The Able Marine Energy Park Development Consent Order

Planning Inspectorate Reference: TR030001

**Written summary of the oral representations of C.RO Ports Killingholme Limited at
the Issue Specific Hearing on the draft Development Consent Order**

23 July 2012

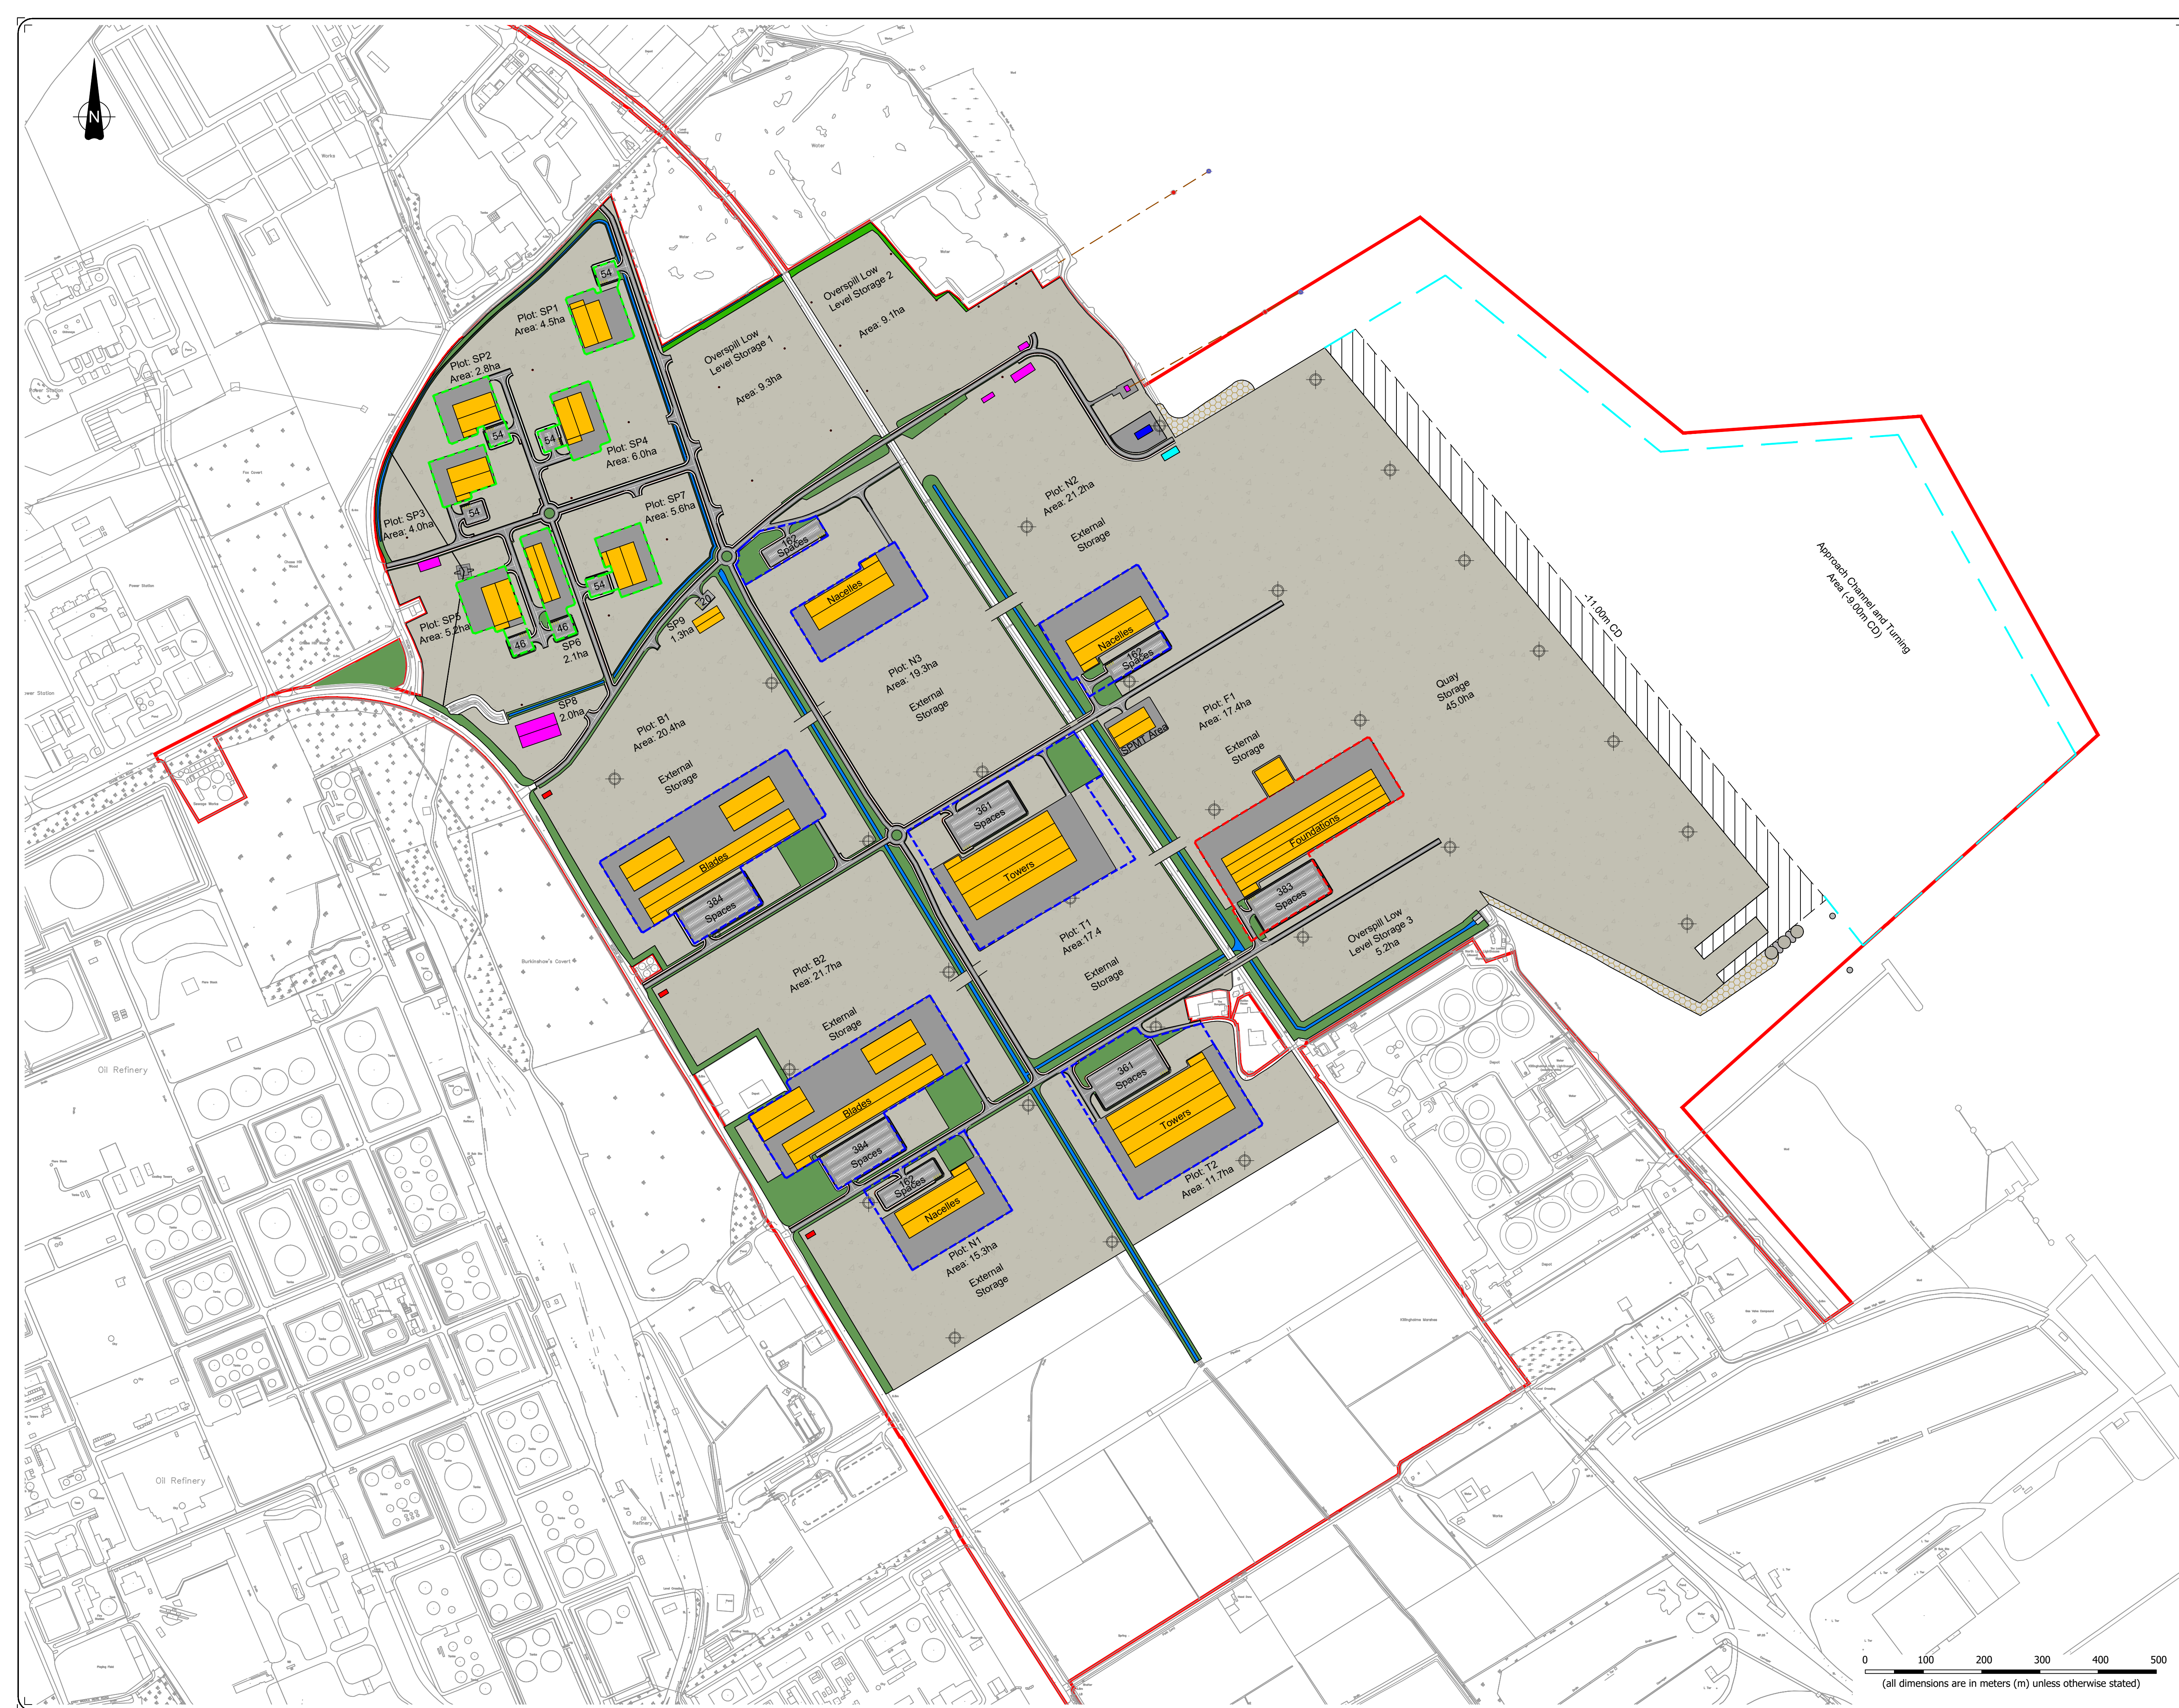
4. The design of AMEP is currently addressed in design drawings, which are for Work No. 1 only, and in a collection of drawings marked "planning application drawings" that do not appear to be referred to anywhere in the DCO or the requirements attached to it. Those planning application drawings include drawings that are confusingly labelled "indicative".

This includes an Indicative Masterplan drawing, the purpose of which is unclear. Notwithstanding its name, it appears to show a layout for the landside elements of AMEP, including three level crossings. How this will be delivered or secured - if at all - is not certain.
